DRB Application No.: 07DRB-00270 (SBP)
Project Name: Ladera Business Park, Unit 1
Agent: Claudio Vigil Architects

**DEVELOPMENT REVIEW BOARD
ACTION SHEET**

RE: Tract 9, Ladera Business Park/sketch

RE: Ladera Business Park, Tract 9, Unit One
Site Development Plan for Building Permit

CONCEPTUAL GRADING & DRAINAGE PLAN

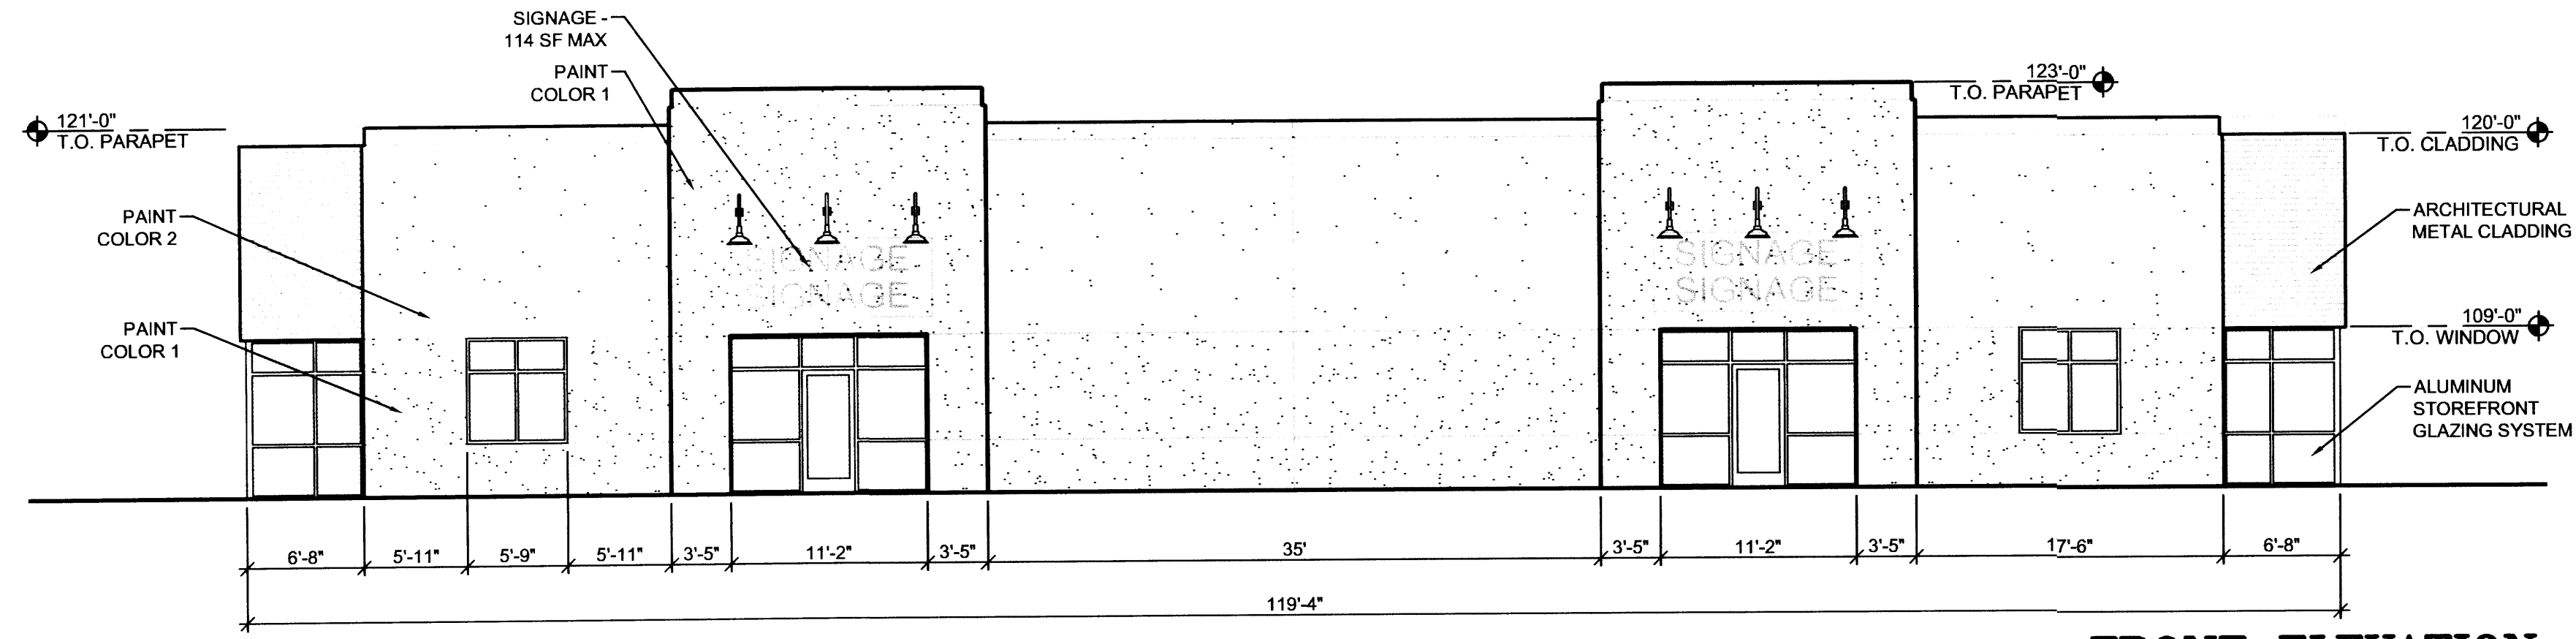
An approved conceptual grading and drainage plan must be on file prior to site plan approval.
The drainage easement must be shown on the site plan.

SHEET TITLE
SITE PLAN
FOR
BUILDING PERMIT

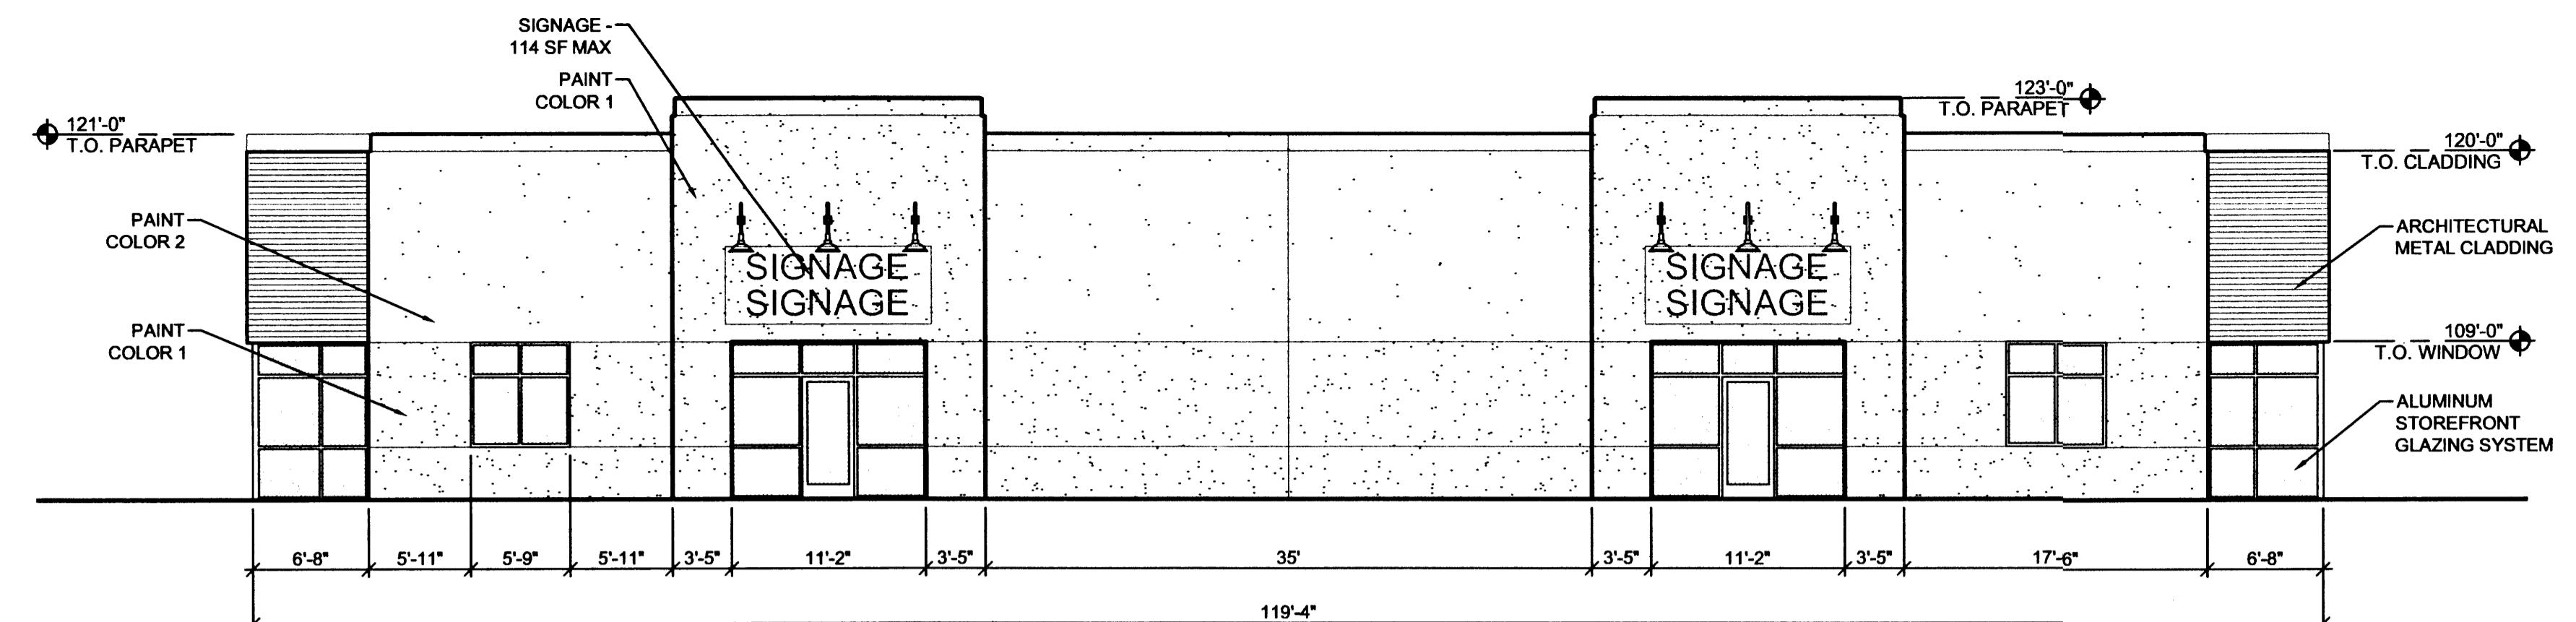
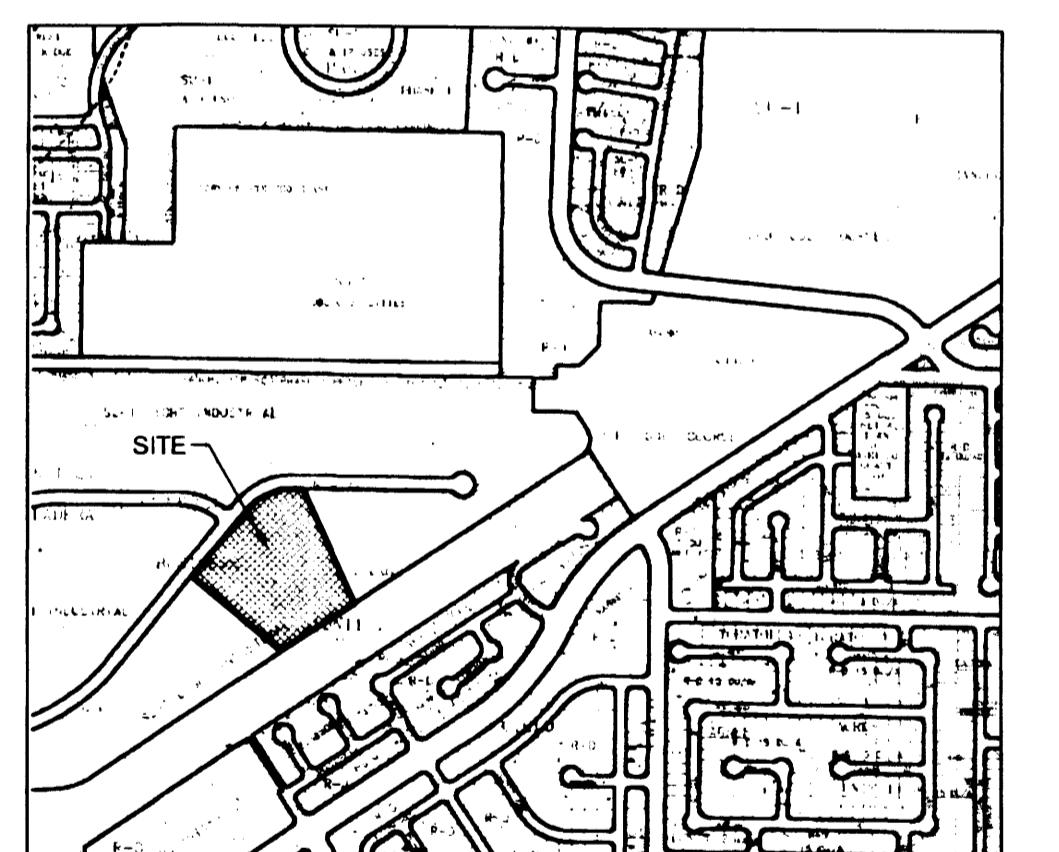
A site plan with landscape plan required per the Ladera Business Park Master Plan checklist.

1. It will be necessary to add a "Utility Plan Sheet" to the submittal to show fire hydrants, fire lines, water meter taps, and sewer service lines.
2. It will be necessary to get the City's Fire Marshal's approval for placement of fire hydrants on this parcel to adequately protect the proposed buildings.
